CITY OF ALBUQUERQUE

February 7, 2017

RE: Townhomes for Greg Lobberegt
Grading and Drainage Plan
Engineer's Stamp Date 2-6-2017 (File: H22D026)

Based upon the information provided in your submittal received 2-6-2017, the above referenced Grading and Drainage Plan is approved for building permit and SO-19 permit.

DRAWING TITLE:
PREDESIGN TRAFFIC CONTROL
LAYOUT

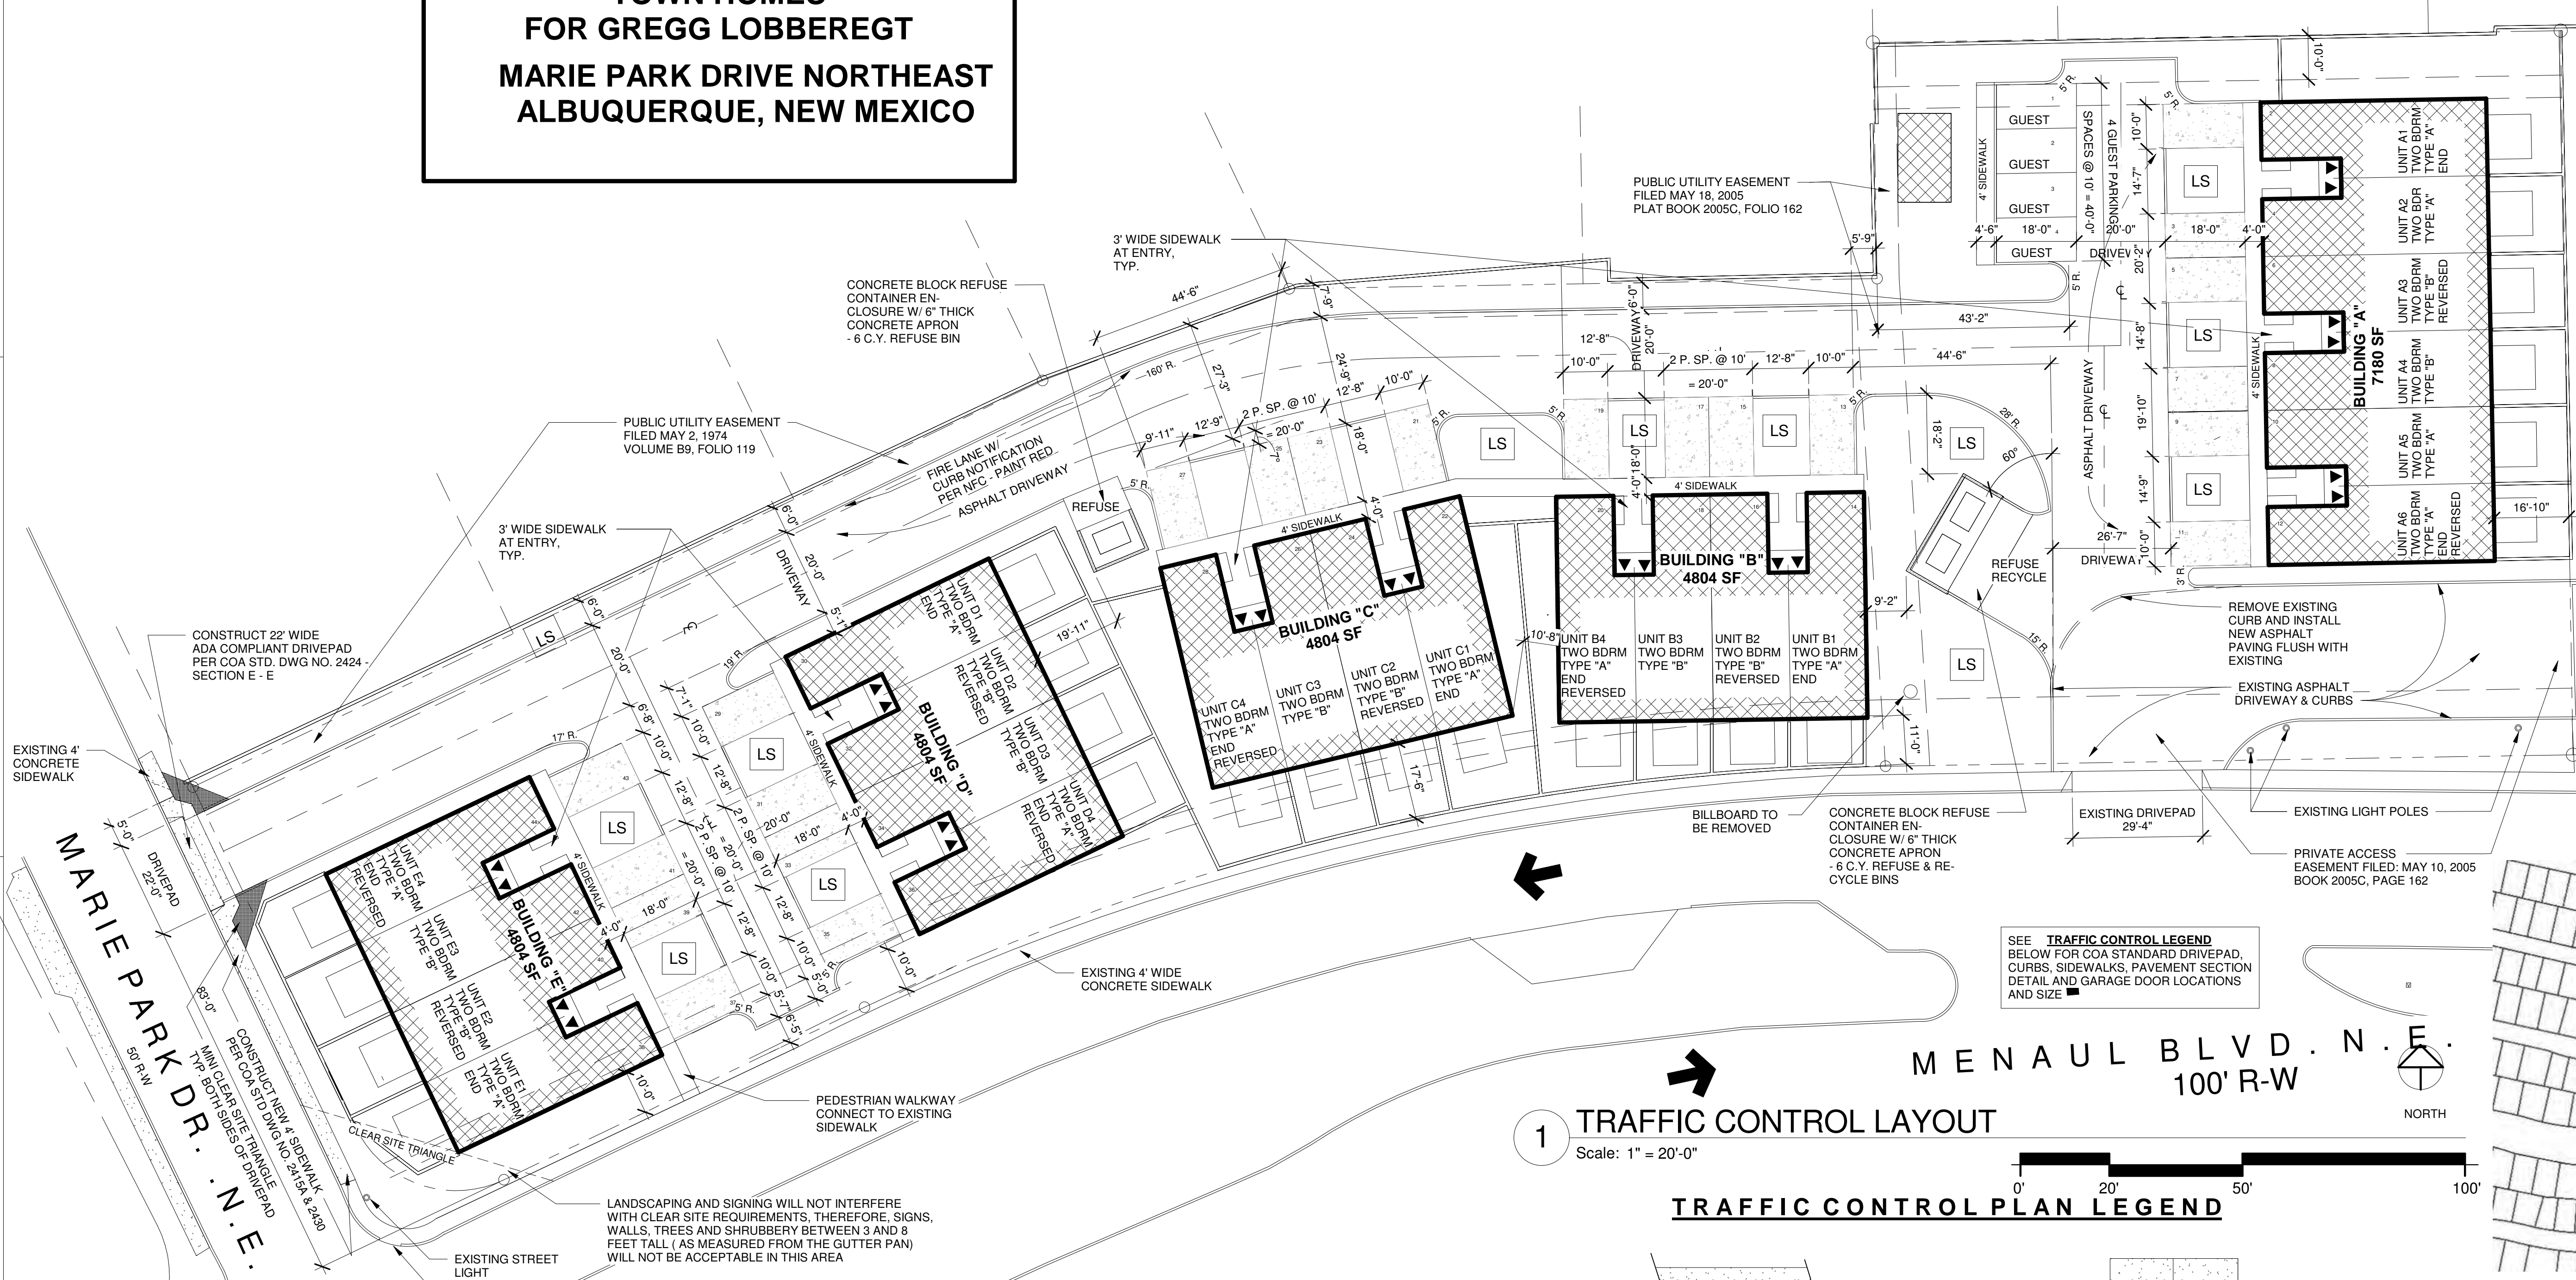
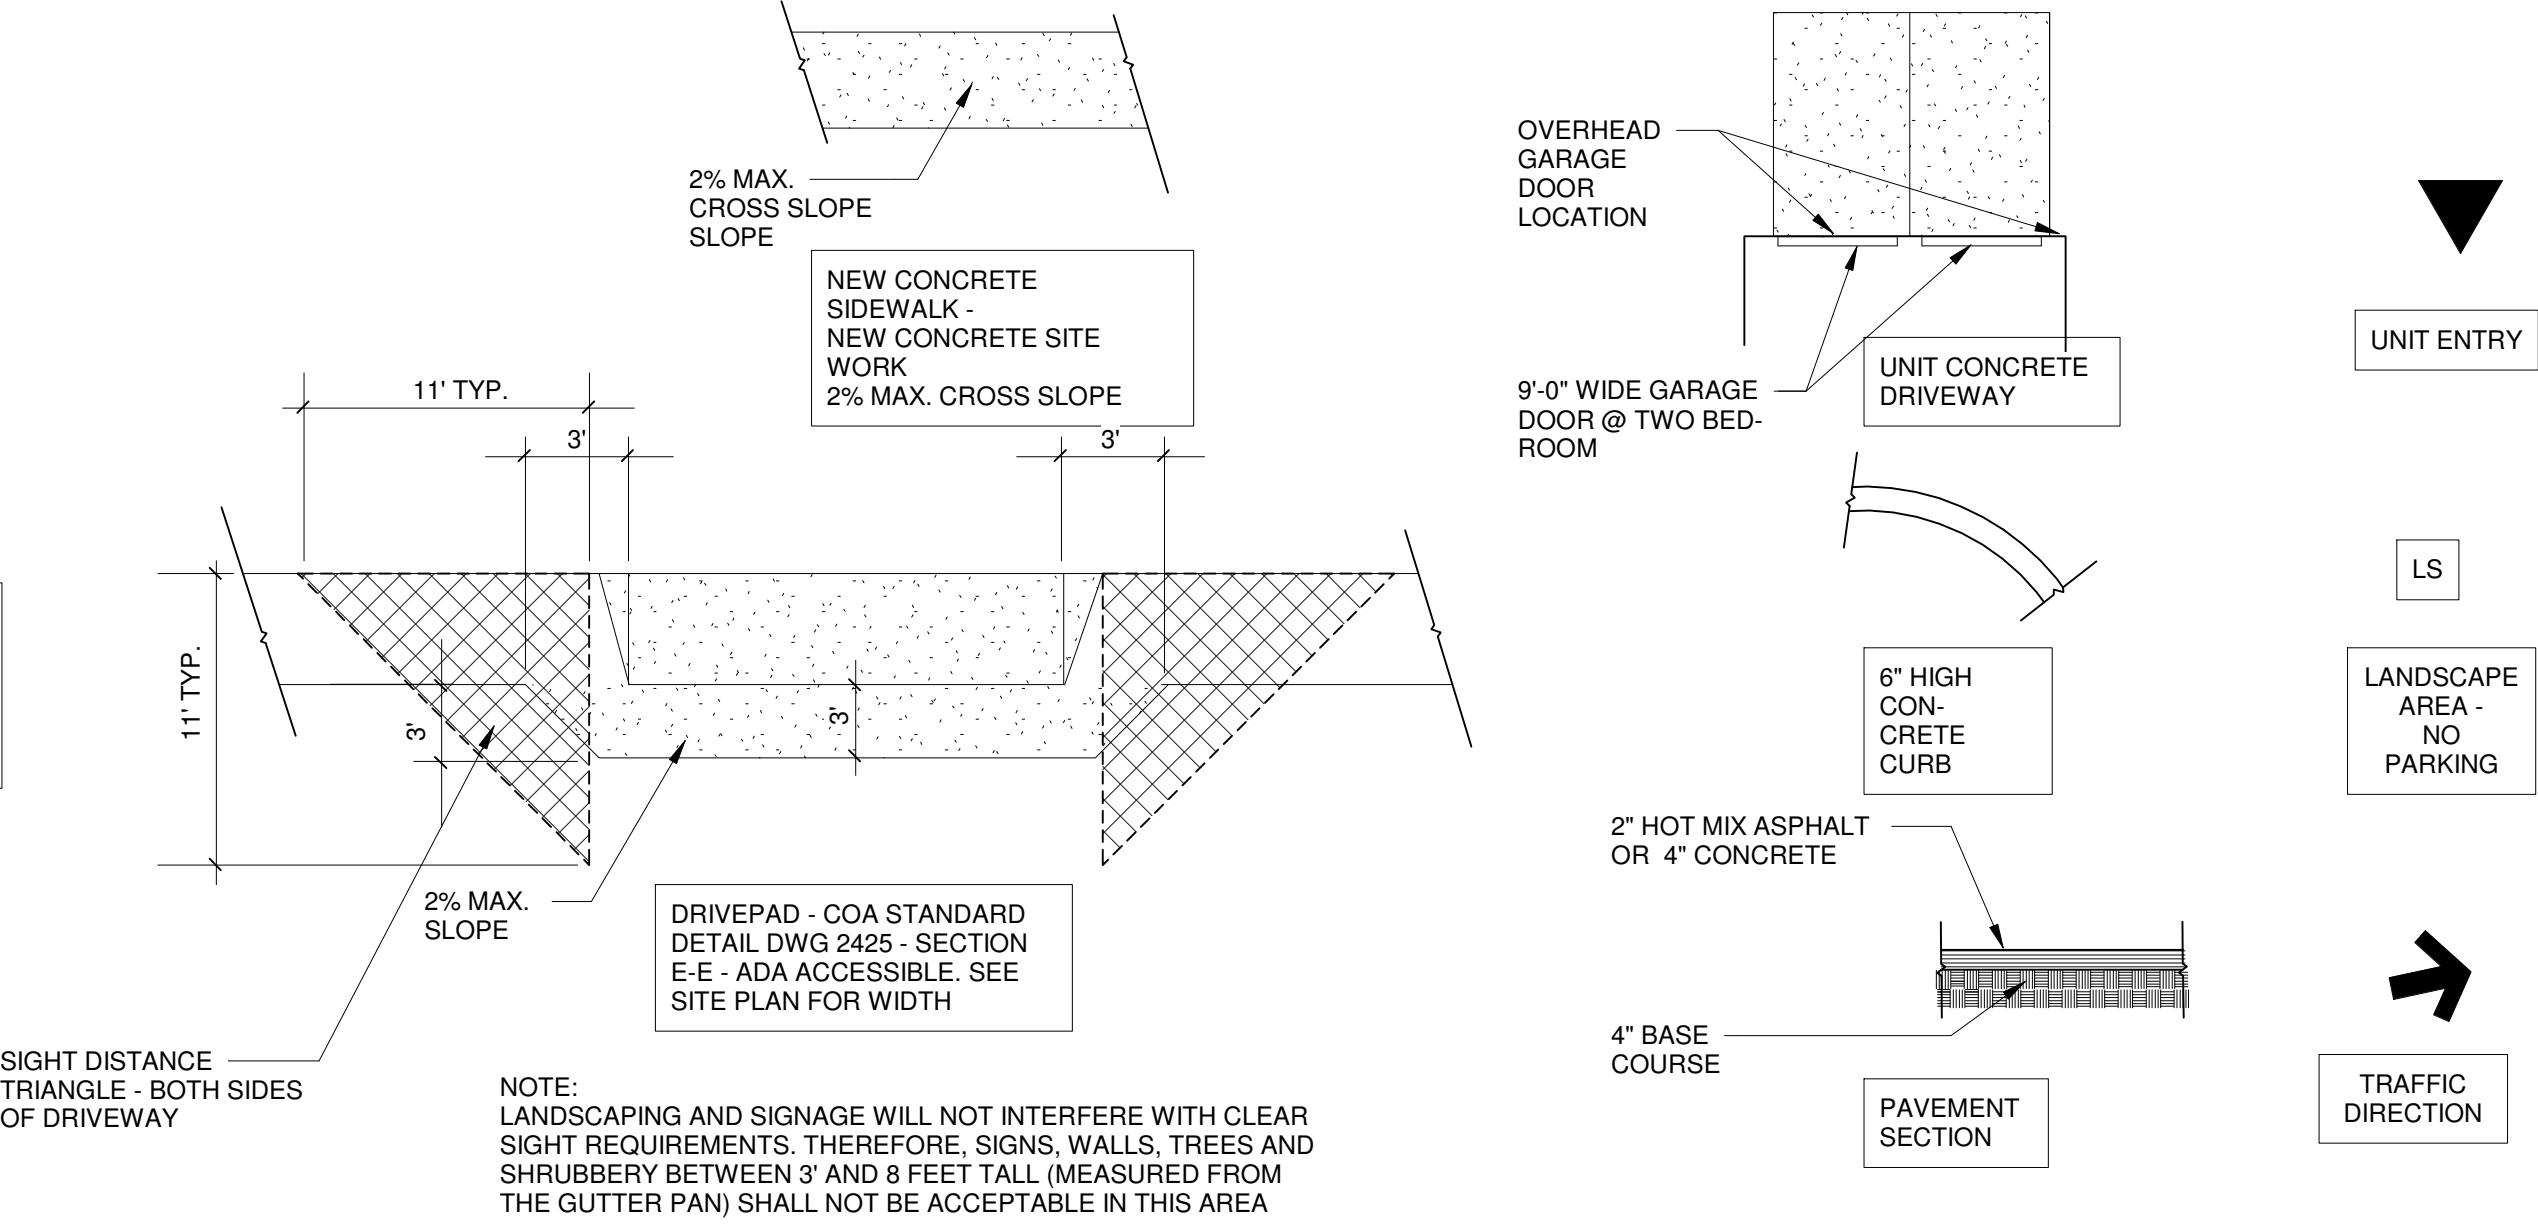
1. List the number of parking spaces required by the zoning code as well as the proposed number of parking spaces including bicycle and motorcycle parking. *152' c every 2 units*

2. Please list the width and length for all ~~existing~~ and proposed parking spaces. Some dimensions are not shown.
- ~~3. The handicap accessible spaces must be a minimum of 8.5 ft. in width.~~

7. Show the drive aisle width between buildings "E" and "D".
8. DPM chapter 23, Figure 23.7.1 does not apply to major circulation aisles.
9. Drive aisle width less than 24' must be one-way vehicular paths that require pavement directional signage and a posted "Do Not Enter" sign at the point of egress. Please show detail and location of posted signs. *Shelub*

10. List radii for the Solid waste refuse between buildings "D" and "C". Radius for delivery trucks, fire trucks, etc. is 25 ft. or larger.
11. A 5 ft. keyway is required for dead-end parking aisles.

12. Per the zoning code, a 6 ft. wide ADA accessible pedestrian pathway is required from the public sidewalk to the building entrances. Please clearly show this pathway and provide details.

13. Per DPM, a 6 ft. wide ADA accessible pedestrian pathway is required from the HC parking stall access aisles to the building entrances. Please clearly show this pathway and provide details.

14. Service vehicle and/or refuse vehicle maneuvering must be contained on-site; provide a copy of refuse approval.
15. It is not apparent what type of pavement surface is being proposed. A hard driving surface will be required as part of this proposed project for parking area and drive aisles.

16. Please specify the City Standard Drawing Number when applicable.
17. Please include a copy of your shared access agreement with the adjacent property owner.

18. See Chapter 23, Section 6 of the City of Albuquerque *Development Process Manual*, for appropriate drive pad widths.
19. Add a note stating "All broken or cracked sidewalk must be replaced with sidewalk and curb & gutter." A build note must be provided referring to the appropriate City Standard drawing.
